WR number: Ref 180 - V 005 (previous WR 1245)
SIDRA Model Review
SIDRA files metadata

Provided by	Masa Kimuar
Email	masa.kimura@transport.nsw.gov.au
Date provided	17/06/2026
Sidra file	20260611 - Supporting Information - P6458.005M Newcastle Indoor Sports Facility TIA SIDRA Models_Survey Sensitivity.sip9 20250819 - SIDRA Models - P6458.004M Newcastle Indoor Sports Facility TIA.sip9
Scenarios	2024 Base Newcastle Indoor Sports Facility - WE Peak Fine Weather Adjustment Newcastle Indoor Sports Facility - WE Peak Project - WE Peak 2024 Project Project - WE Peak
Supporting documentation	20260519 - Supporting Document - Appendix I - SIDRA Technical Note - Hunter Indoor Sports Centre - RTS 2_EXH-90849960.pdf 20260611 - Supporting Information - P6458.005T Newcastle Indoor Sports Facility TIA Modelling Technical Note.pdf
Model reviewer	Angel Shrestha
Email	Angel.SHRESTHA@transport.nsw.gov.au
Review date	23/06/2026

Ref 180 - V 005 (previous WR 1245)									
SIDRA Model Review									
Review findings									
Status	SIDRA file (sip)	Scenario ID / Section	Intersection	Category	Review comment	Model developer response	Review Comment	Review Comment V005	
Minor	20241023 - Supporting Document -

**Site: 105 [Turton Road / Lambton Road / Bridges Road - TCS  
350 (Site Folder: 2024 Base AM Peak)]**

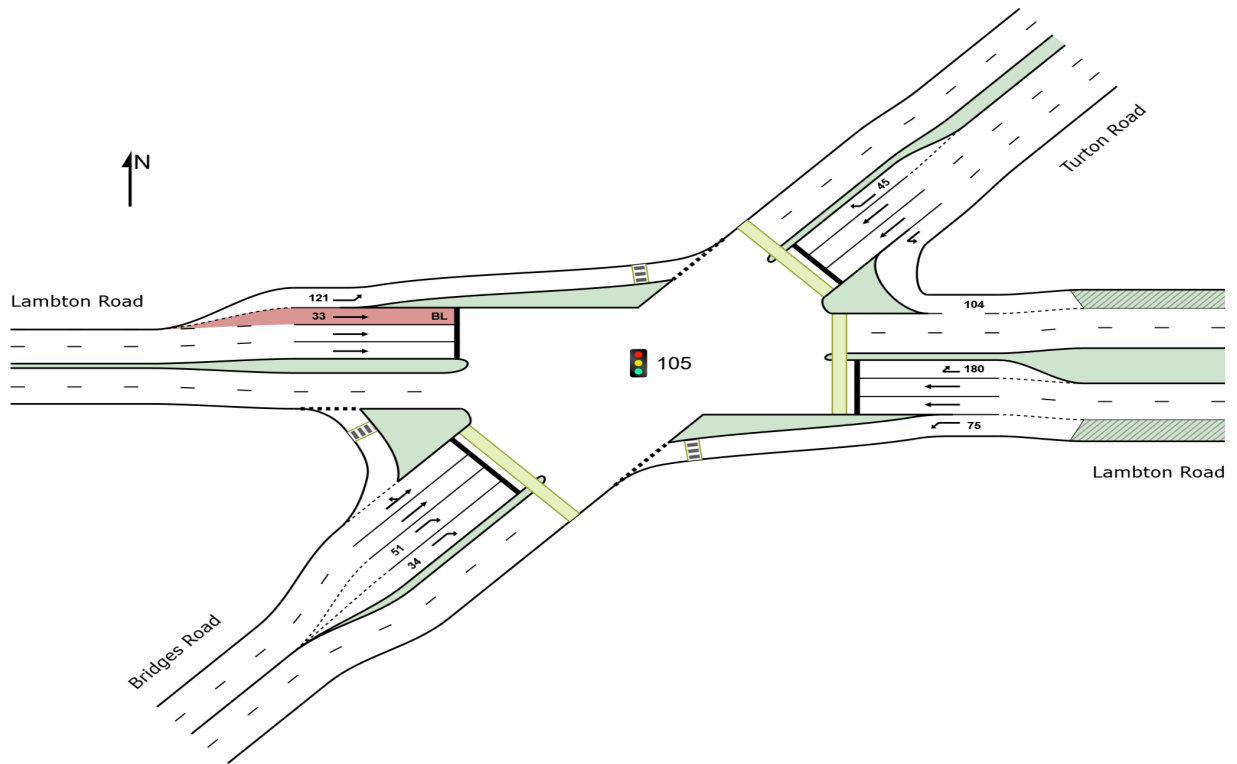
Closed	20241023 - Supporting Document - SIDRA - P6458.002M Newcastle Indoor Sports Facility TIA SIDRA Models.sip9	All Scenario	All TCS Sites	Vehicle Movement Data - Signals	Arrival type > 4 should only be used when there is a very short distance between coordinated signalised intersections, however it was found to be used on approaches with significant distance from the next signalised intersection. Please document reasoning for adopting arrival type 5 and 6 in the model. Start loss changed from default value of 3 to 1 for Young Rd and Minor phase actuation set as % phase = 100 %. Please provide reasoning for the change	Offset times were extracted from the LX file, and the intersections were modelled at the network level, incorporating real-time offset time values from the LX. The Start Loss and Minor Phase Actuation values were revised to default values at the affected intersection.			
Medium	20241023 - Supporting Document - SIDRA - P6458.002M Newcastle Indoor Sports Facility TIA SIDRA Models.sip9	All Scenario	All TCS Sites	Phasing and Timing	It was observed that Optimum Cycle time was used for Project Update PM peak scenario. Use of Optimum Cycle is not supported. Please provide reasoning for adopting and changing Red Arrow Drop off from SIDRA default value of 5 sec. Please provide reasoning for adopting Phase transition. Use 120. Please seek concurrence from TNSW NOPS team for signal phase and time / signal coordination and any changes to it in the model	A practical cycle time will be adopted instead of optimum. Red Arrow Drop was removed from the Young/Turton intersection signal coding. All phase transitions have been removed from the Sidra models. All signal phase and offset times were adopted directly from SCATS and LX data provided by TNSW .	Please update signal phase as per TCS plan. Allow for ped in Phase A for TCS 201 Allow for ped and filter right in Phase D for TCS 350 Please seek concurrence from TNSW NOPS for signal phase and time.	It was observed that partial update has been made in V005 but since V05 only contains sensitivity test, please also update V004. Please update signal phase as per TCS plan. Allow for ped in Phase A for TCS 201 Allow for ped and filter right in Phase D for TCS 350 Please seek concurrence from TNSW NOPS for signal phase and time.

Site: 101 [Turton Road / Griffiths Road - TCS 201 (Site Folder: 2024 Base AM Peak)]

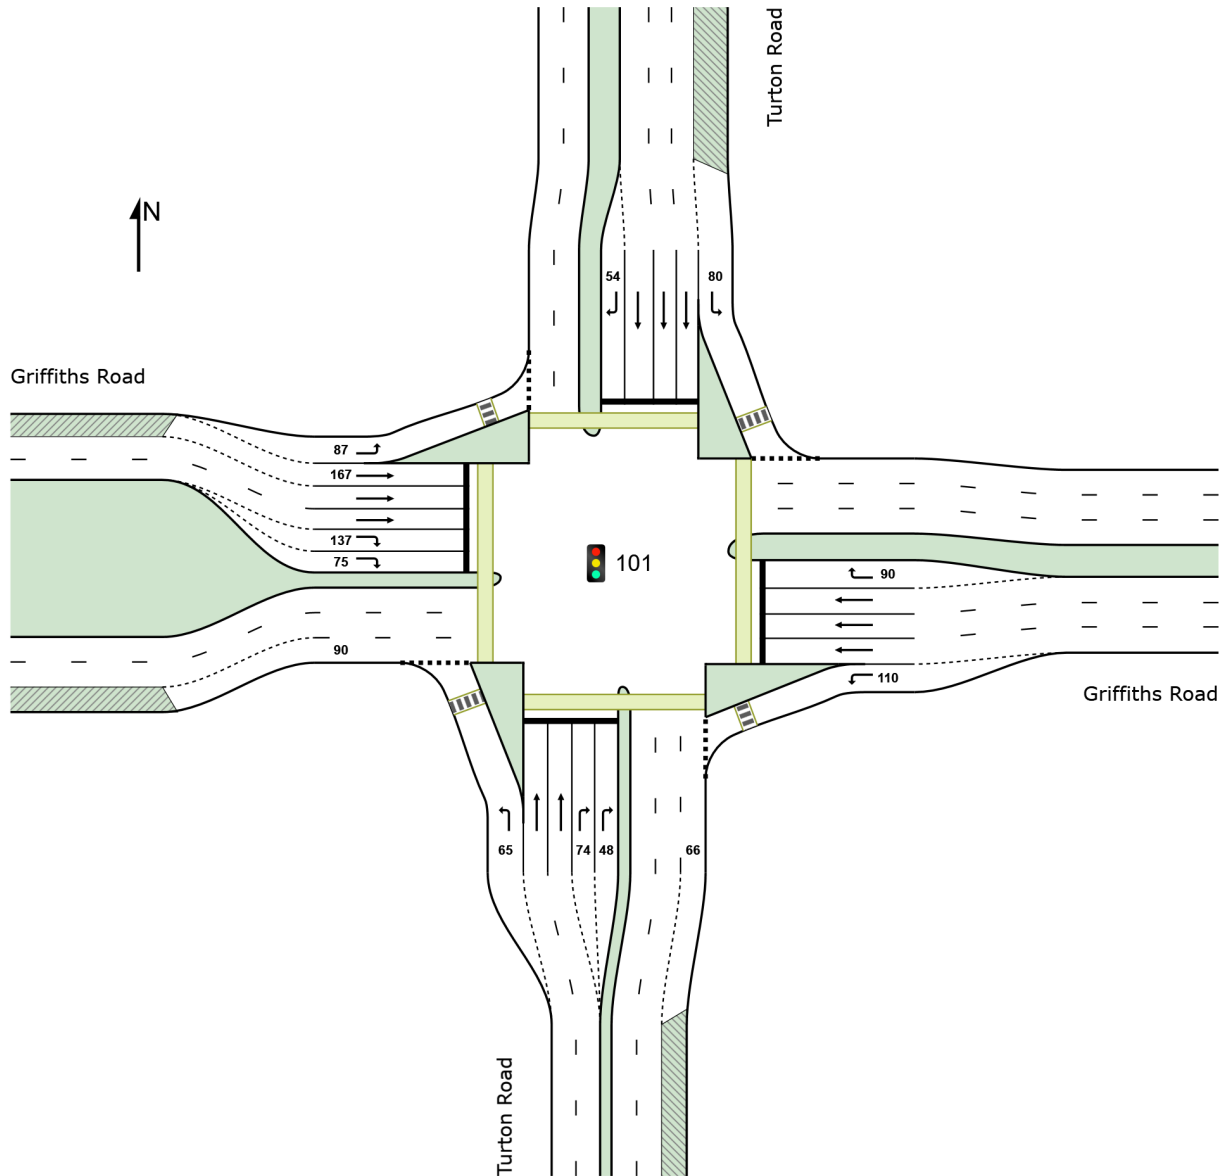
Closed	20241023 - Supporting Document - SIDRA - P6458.002M Newcastle Indoor Sports Facility TIA SIDRA Models.sip9	All Scenario	Turton Road / Griffiths Road - TCS 201 Turton Road / Lambton Road / Bridges Road - TCS 350	Geometry	Please update lane configuration at north approach for TCS 201 to match site condition (as observed in google earth image) or document reasoning for the change. It was observed that length of lane was different during AM, PM and Weekend peak for TCS 350. Please update.	The northern approach at Turton Rd Lane 2 has been converted to a short 40-meter lane in all scenarios. The length of the left turn lane on Lambton Street should be modelled longer in the PM peak due to the "No Stopping" zone enforcement along this restricted parking area during the PM peak.			
Closed	20241023 - Supporting Document - SIDRA - P6458.002M Newcastle Indoor Sports Facility TIA SIDRA Models.sip9	2024 Base PM Peak 2024 Project PM Peak 2024 Project Update PM Peak	Turton Road / Griffiths Road - TCS 201 Turton Road / Lambton Road / Bridges Road - TCS 350	Volume Factors / Peak Flow Factor	It was observed that Peak Flow Factor was changed from default Sidra value of 95%. Please provide reasoning for the change and calculation for Peak Flow Factor.	The peak flow factor values have been reset to default 95%
